WEST SUSSEX COUNTY COUNCIL CONSULTATION

TO:	Arun District Council FAO: Amber Willard
FROM:	WSCC - Highways Authority
DATE:	29 January 2021
LOCATION:	339 Chichester Road, Bersted, PO21 5AN
SUBJECT:	BE/149/20/PL Replacement of blockwork boundary wall with fence & new vehicular access. This site is in CIL Zone 4 (Zero Rated) as other development.
DATE OF SITE VISIT:	N/A
RECOMMENDATION:	More Information
S106 CONTRIBUTION TOTAL:	N/A

SITE PLAN

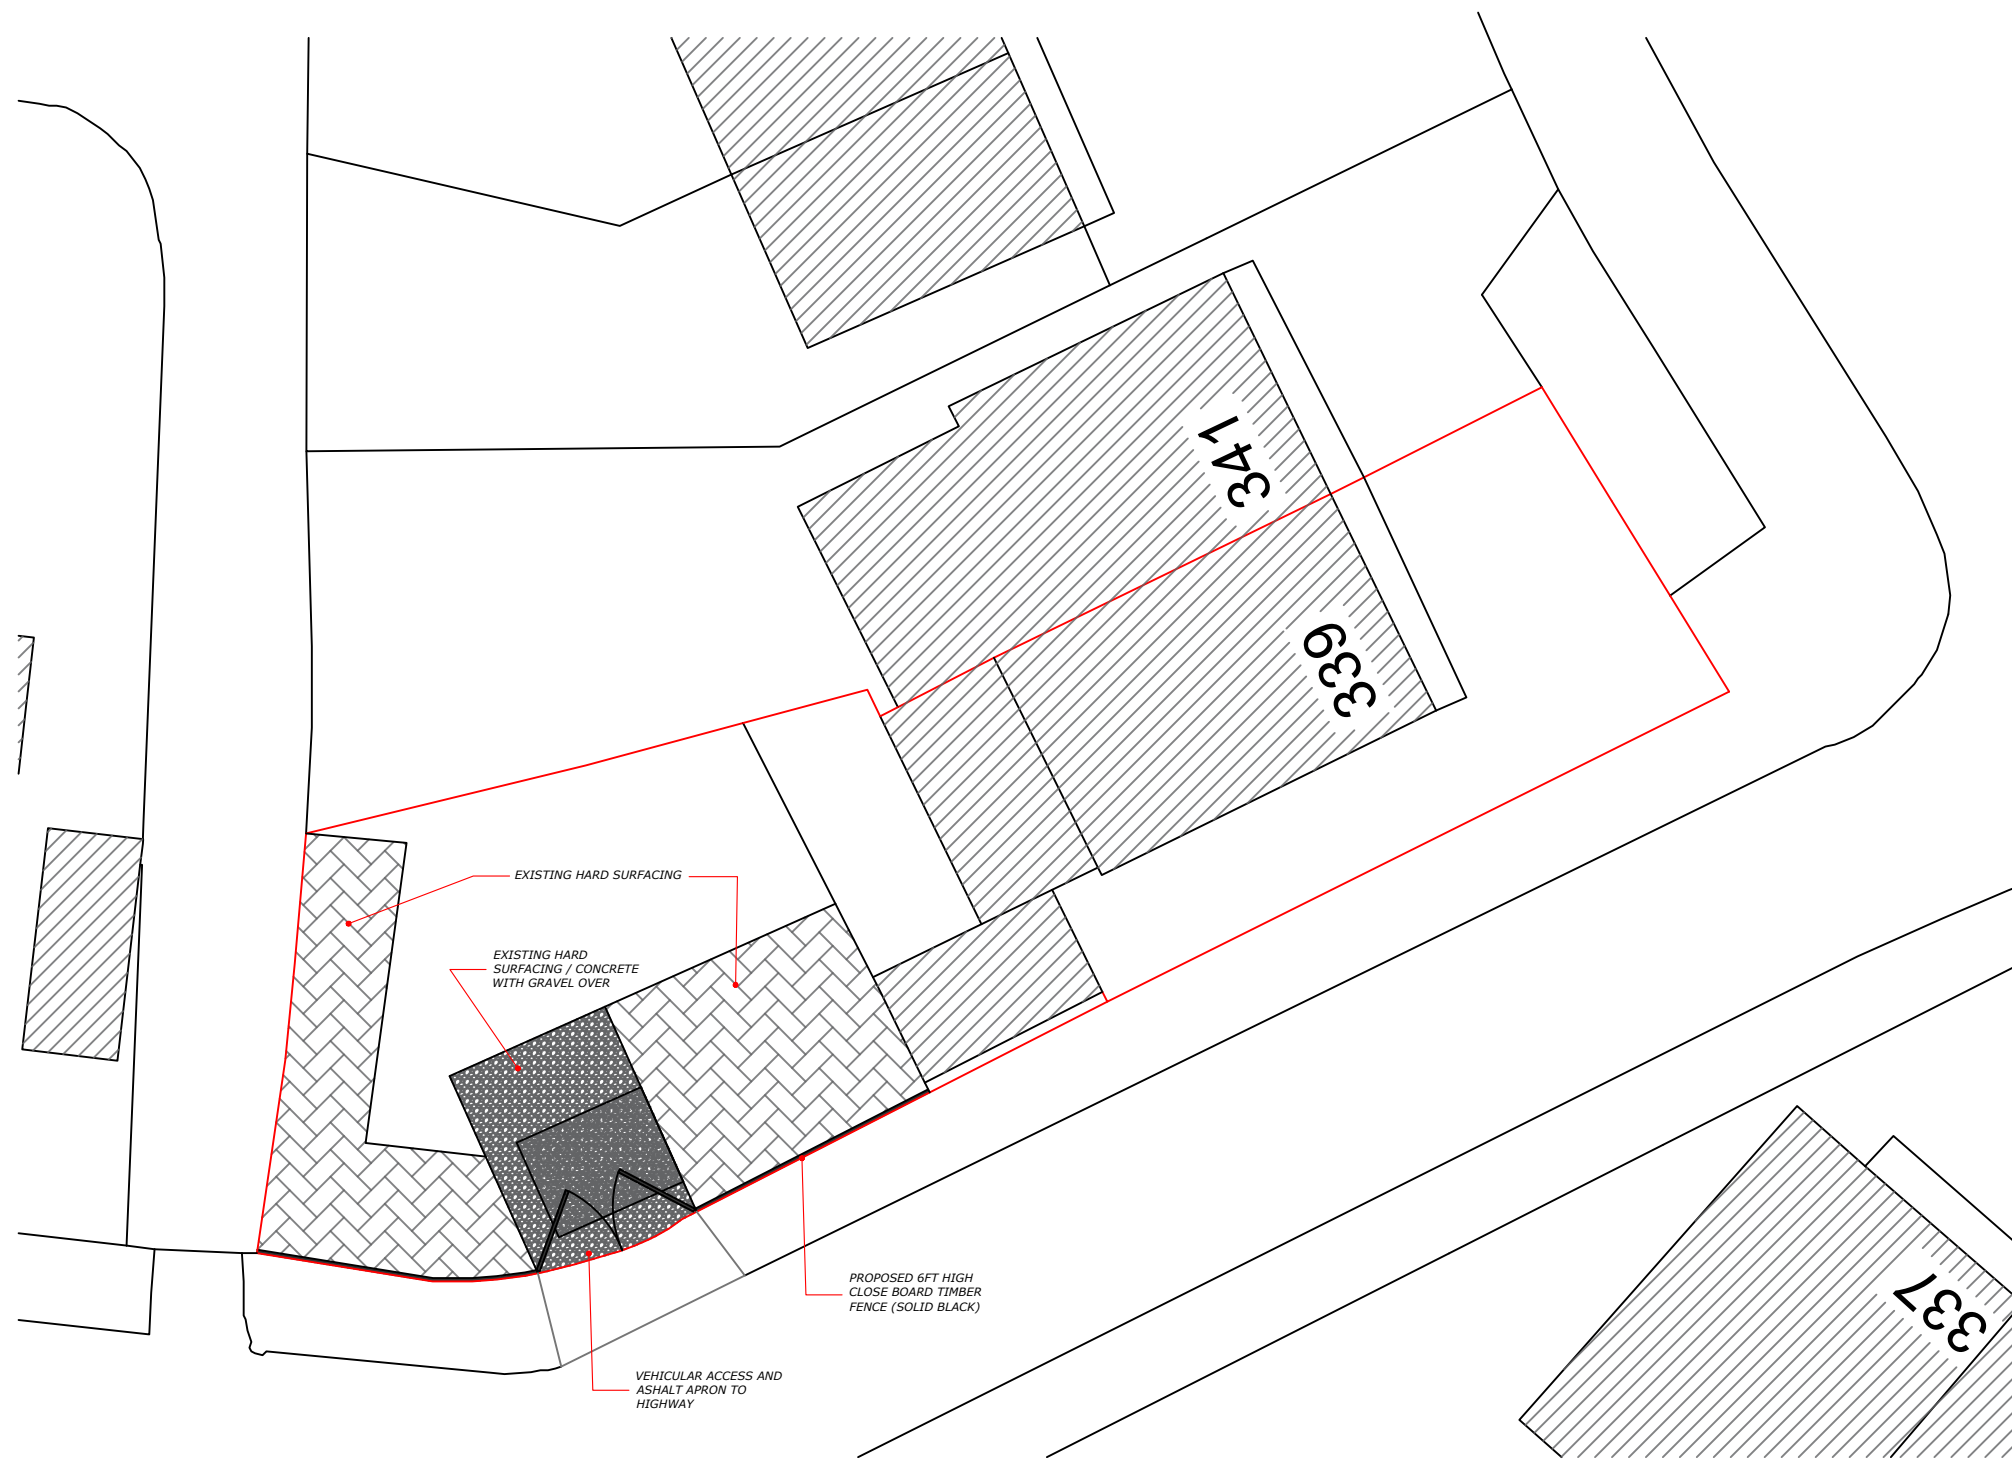
The applicant proposes to a new vehicular access onto Bedford Avenue. However, the applicant has not demonstrated visibility for the proposed access.

The LHA requests the applicant to provide maximum achievable visibility splays for the proposed access. As Bedford Avenue is subject to a speed limit of 30 mph in this location, the applicant should demonstrate vehicular visibility splays in accordance with the Stopping Sight Distance (SSD) requirements for 30 mph roads as set out in Manual for Streets (MfS).

This sets out a minimum stopping sight distance (SSD) of 43m in each direction, drawn from 2.4m from the back edge of the carriageway. The splays must intersect land only within control of the applicant or within the publicly maintained highway and must be drawn to the nearside edge of the carriageway in both directions. If splays of 43m are not achievable, the applicant can support a reduction in splays with a seven-day speed survey.
